Our Ref: P/32/19/HH

**Town & Country Planning Act 1990 (as amended)
Town & country Planning (Development Management Procedure) (England) Order 2015
Application for Planning Permission for Works or Extension to a Dwelling**

Development Single storey side extension
Location 56 Harbour View Road Pagham

BLOCK PLAN

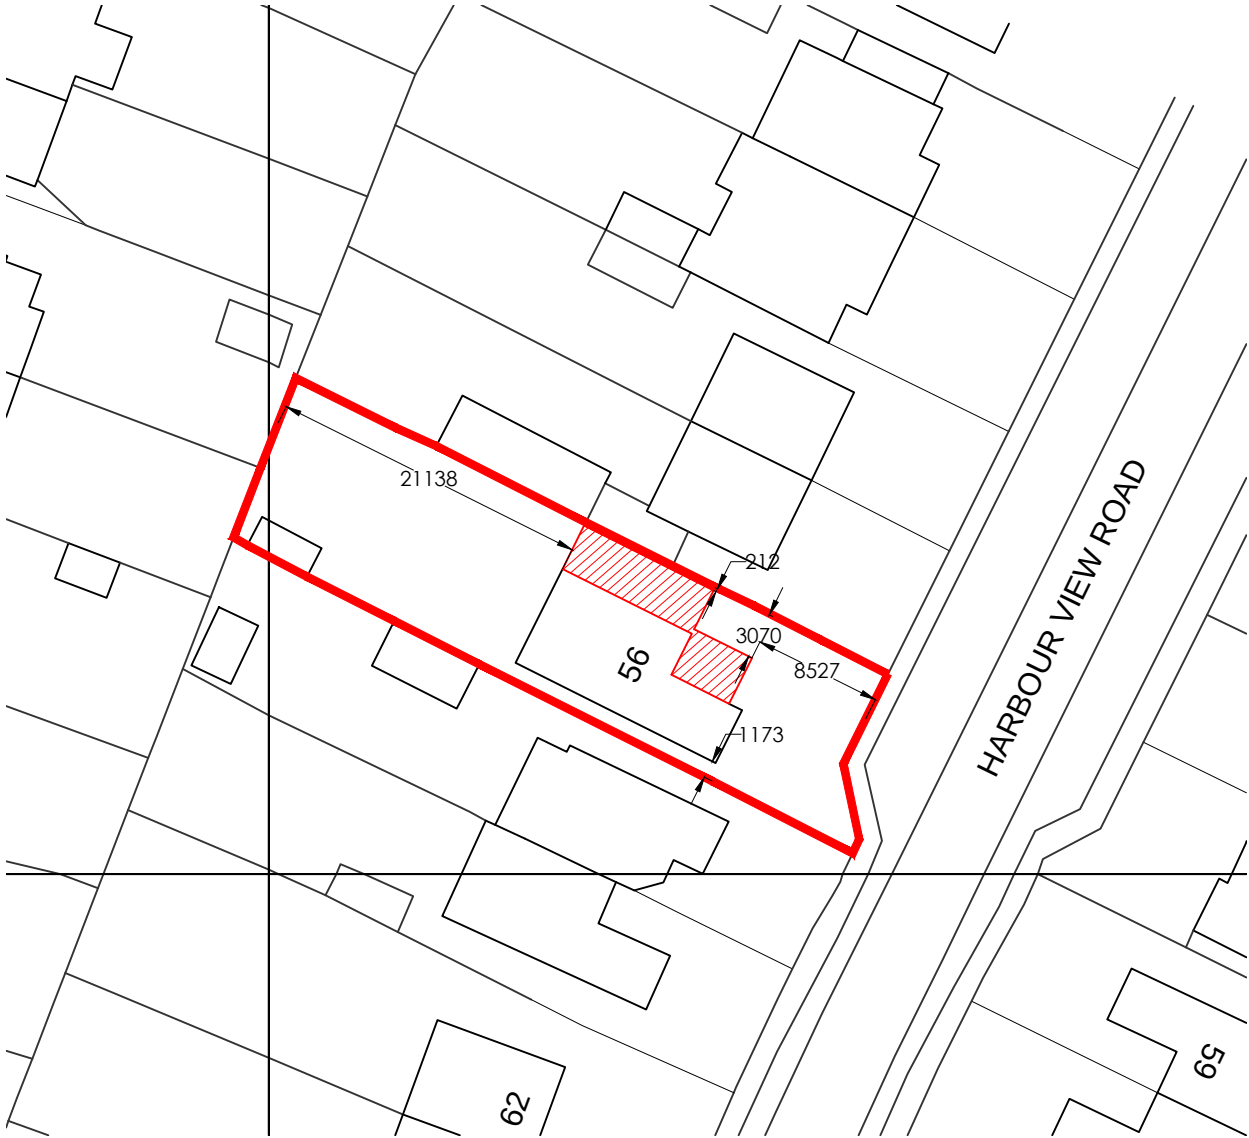
Block Plan

Please submit 1 electronic or 3 paper copies of a block/site plan which includes additional dimensions to the front and rear boundary.
